REVIEW of LVIA

CHERWELL DISTRICT COUNCIL

Application reference: 22/01682/F - Land North of Manor Farm, Noke

April 2024

IMPLEMENTATION AND MAINTENANCE GUIDELINES

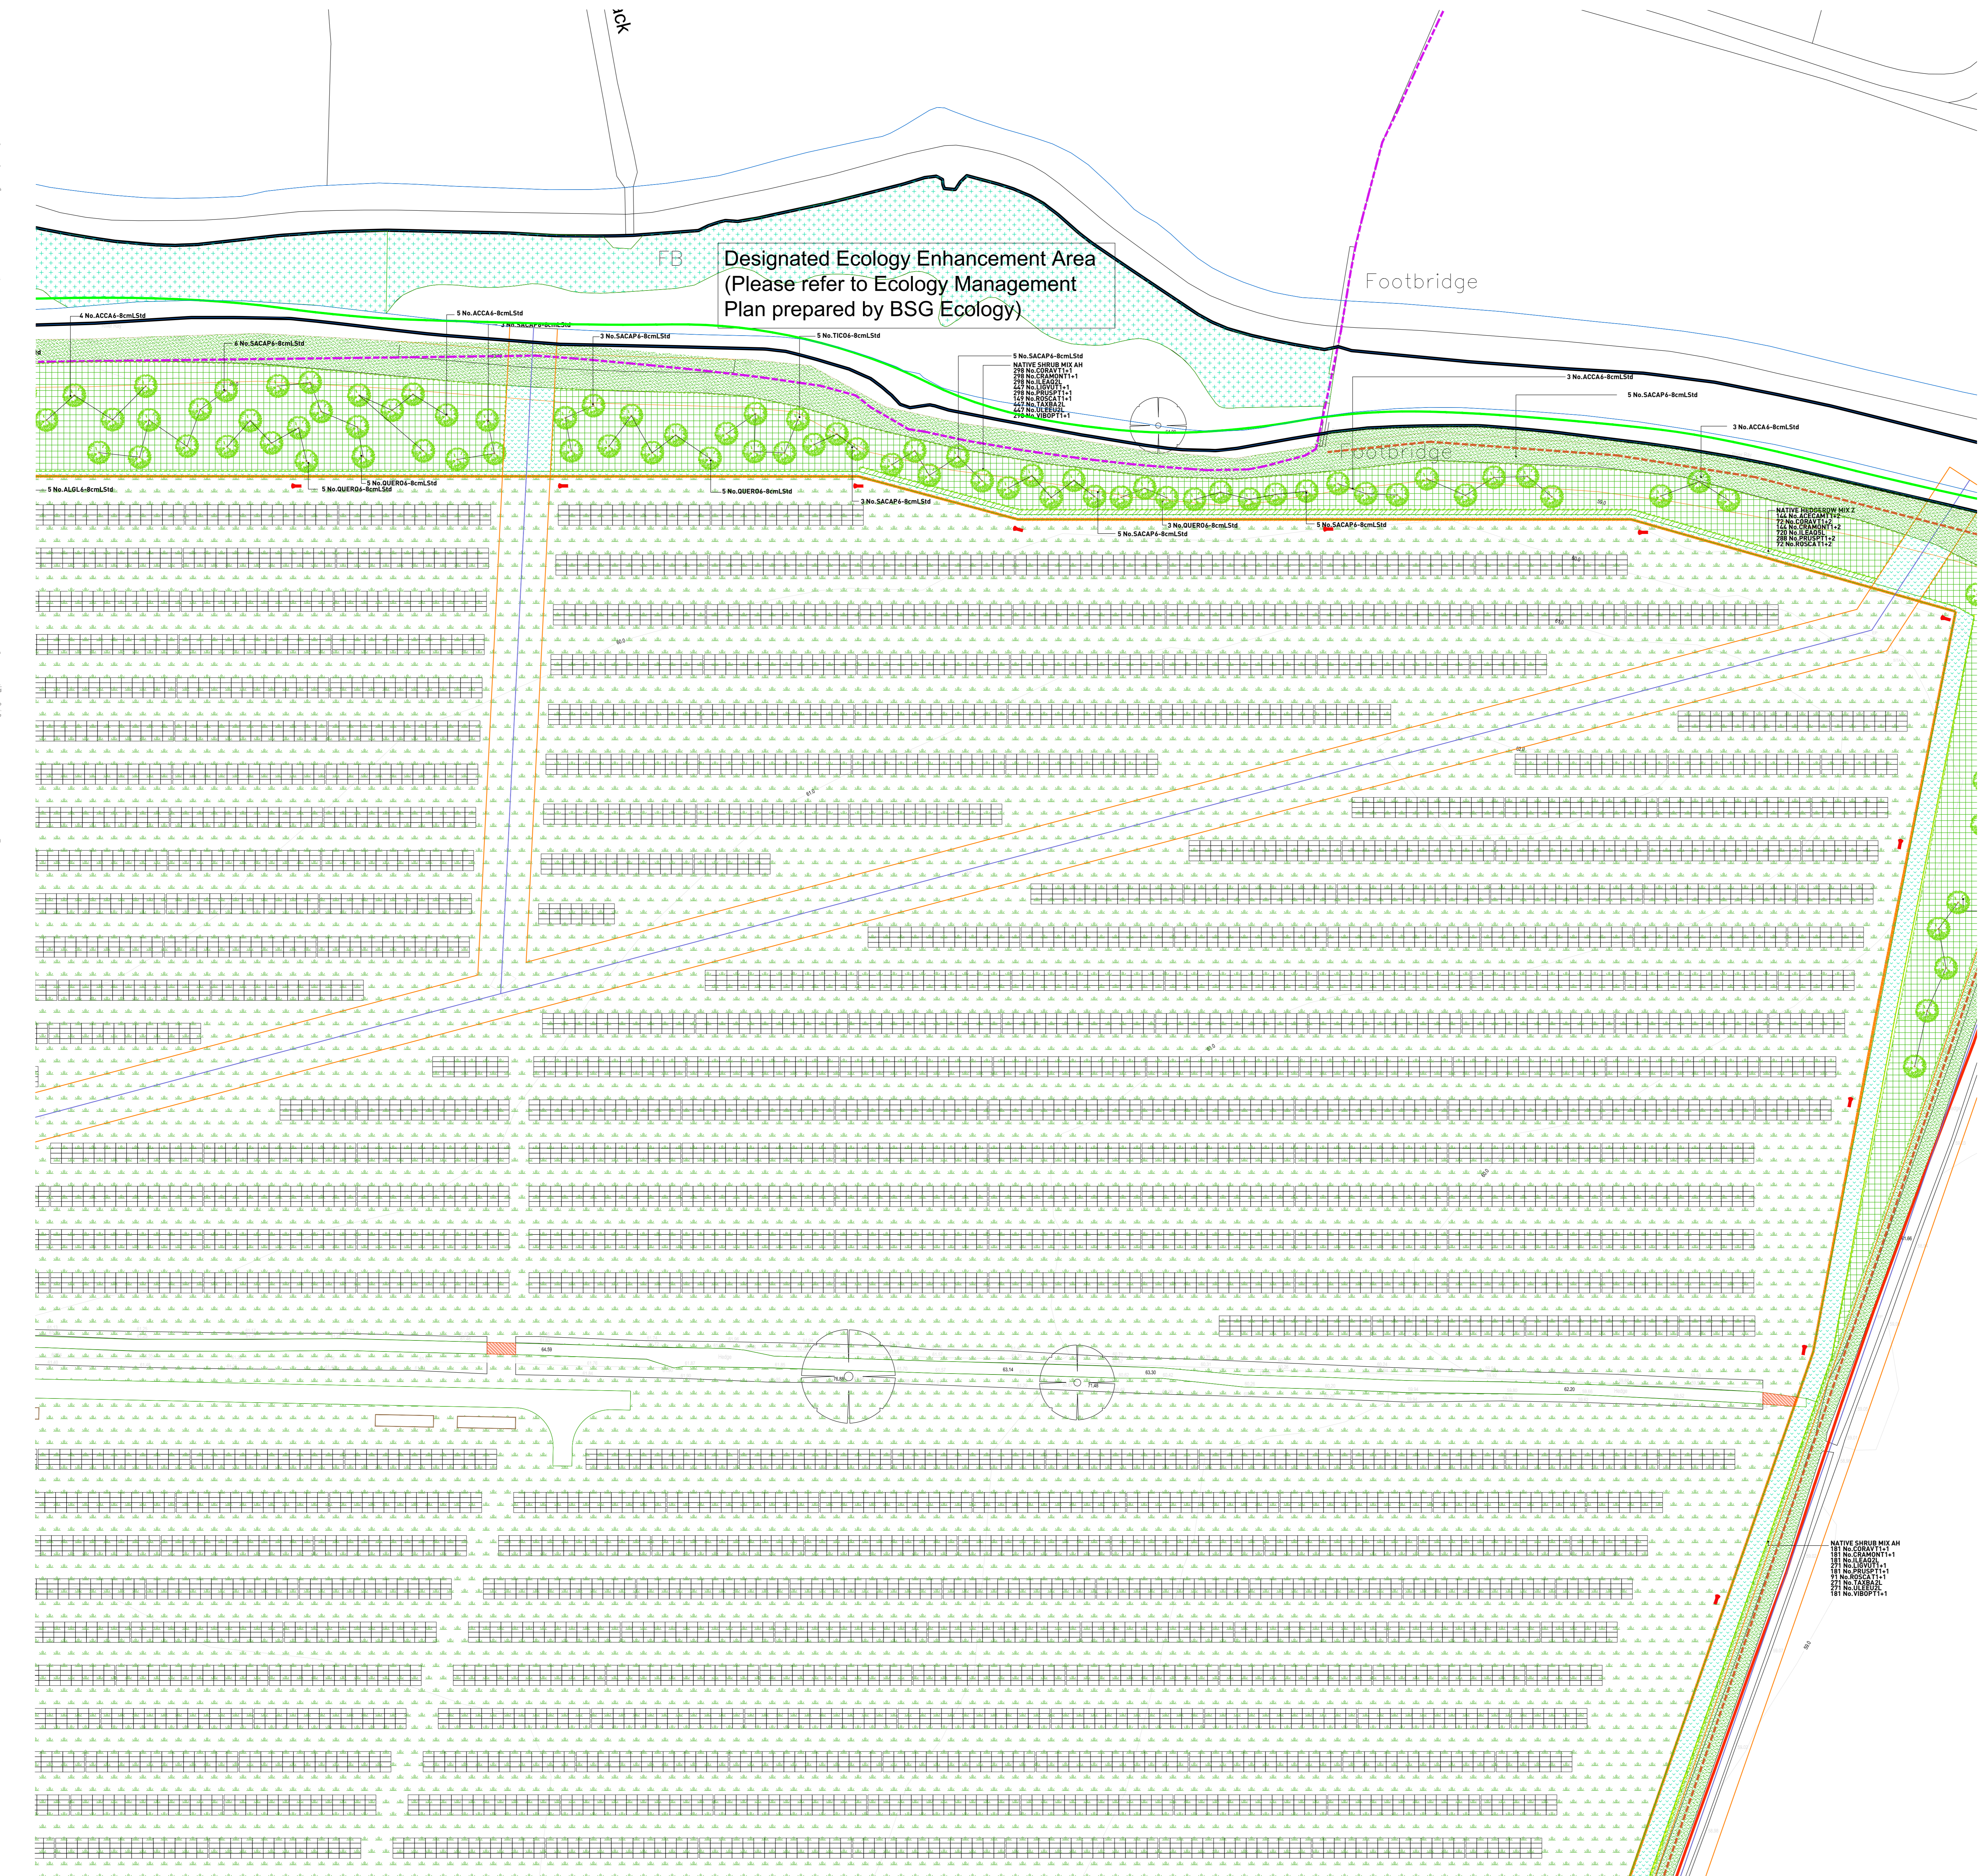
- 3.30 Security fencing is described as having an “offset for maintenance purposes of 4m generally and 1m along the northern boundary adjacent to the river corridor beyond which there is significant proposed planting” (LVIA para. 5.21). The offset is assumed to be from the site boundary but this is not clear. The proposed 2m clearance between the security fencing and existing hedgerow is subsequently described as “enhancement” at LVIA paragraph 5.31 which should be corrected as the security fencing and need to create screening of it, does not enhance.

- 3.32 The proposals incorporate a relatively high percentage of evergreen species

compared to local patterns and species compositions that are typical of the landscape character of the area. Whilst this would assist in providing year round screening value, it is not in our opinion in-character with the wider and local landscape context.
